**Consultation Response from KC,
Ecology Unit**
2025/93543 land at, former Clough Mill, Clough Road, Slaithwaite, Huddersfield, HD7 5DB

Erection of 31 dwellings (c3) with access from Clough Road and associated works including engineering operations, construction of retaining walls and landscaping
Date Responded: 30/09/2026
Responding Officer: Z. Hanshaw
Responding Ref: 2609/59

Figure 2: Map of the Kirklees Wildlife Habitat Network on and adjacent to site.

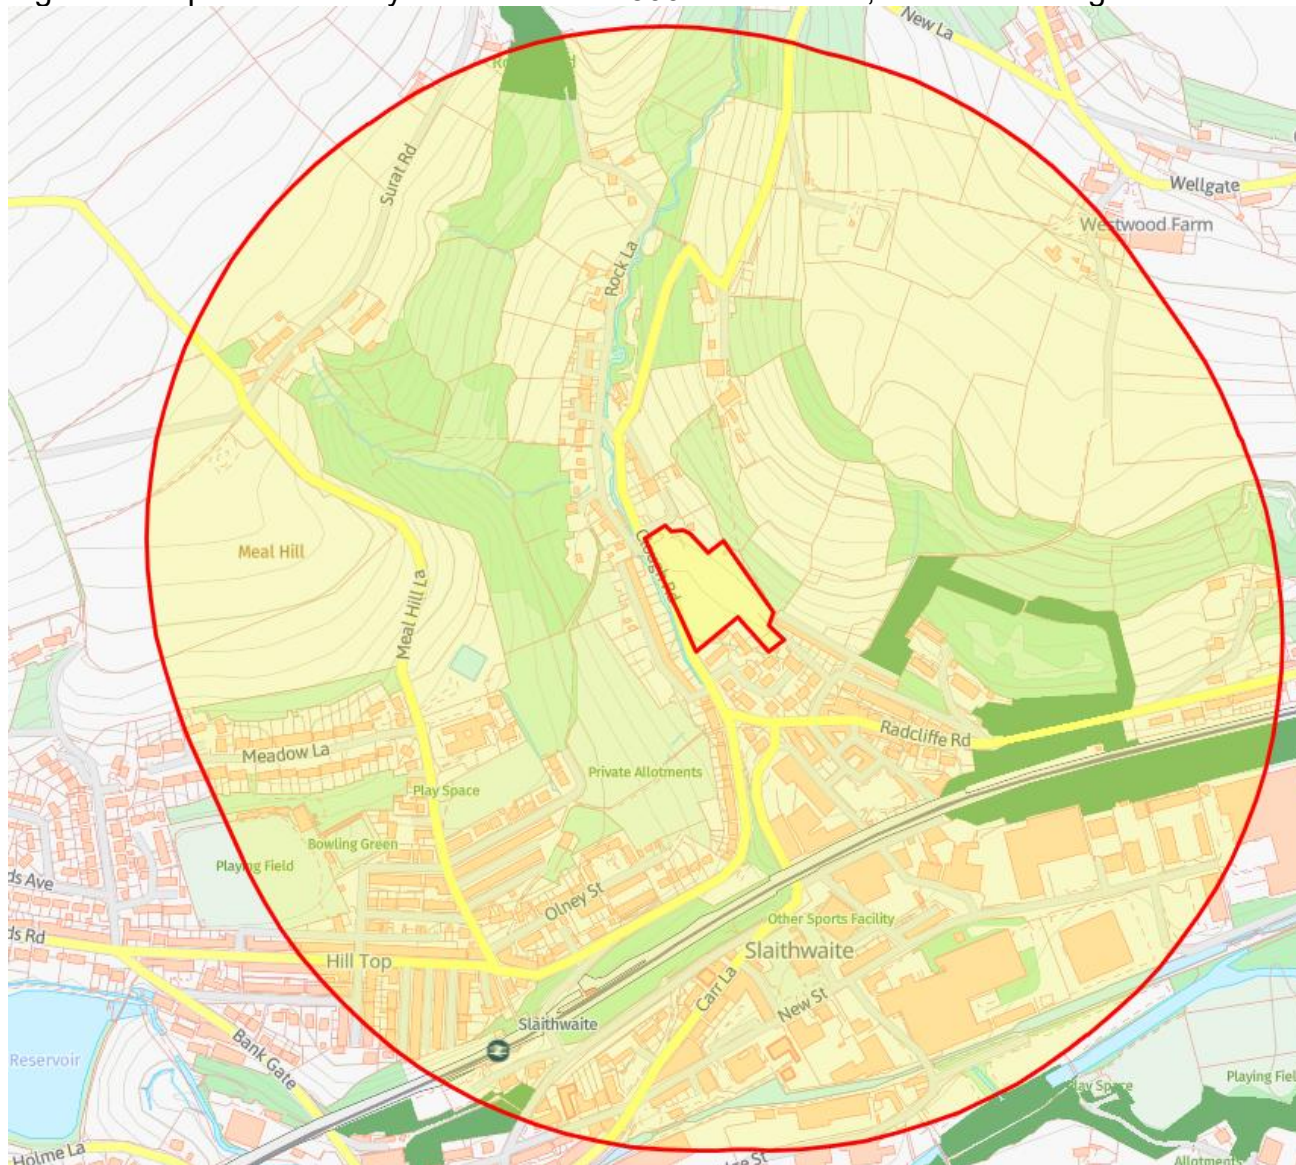
Additionally, since the Biodiversity Net Gain information was submitted, this site has been identified in the West Yorkshire LNRS. The Metric does detail that the Woodland onsite is formally identified in a local strategy, as the site is already designated as part of the Kirklees Wildlife Habitat Network. However, the metric should be updated in line with the published LNRS.

The NPPF 2026 N2c states development should "*take suitable opportunities to connect to and strengthen ecological networks that extend beyond the site, drawing on the measures proposed by Local Nature Recovery Strategies.... And other relevant assessments*" and N2d states development should "*conserve and enhance existing natural features of visual, historic or nature conservation value (such as established trees and hedgerows)*". It is clear that this proposal does

not align with these points in the NPPF, as the site has already been partially cleared with no consideration to the conservation of features of nature value, and no proposals to strengthen ecological networks are included within the scheme design.

Further information to show how this development can be achieved in line with NPPF Policy N2, and the requirements of the Environment Act 2021, should be provided.
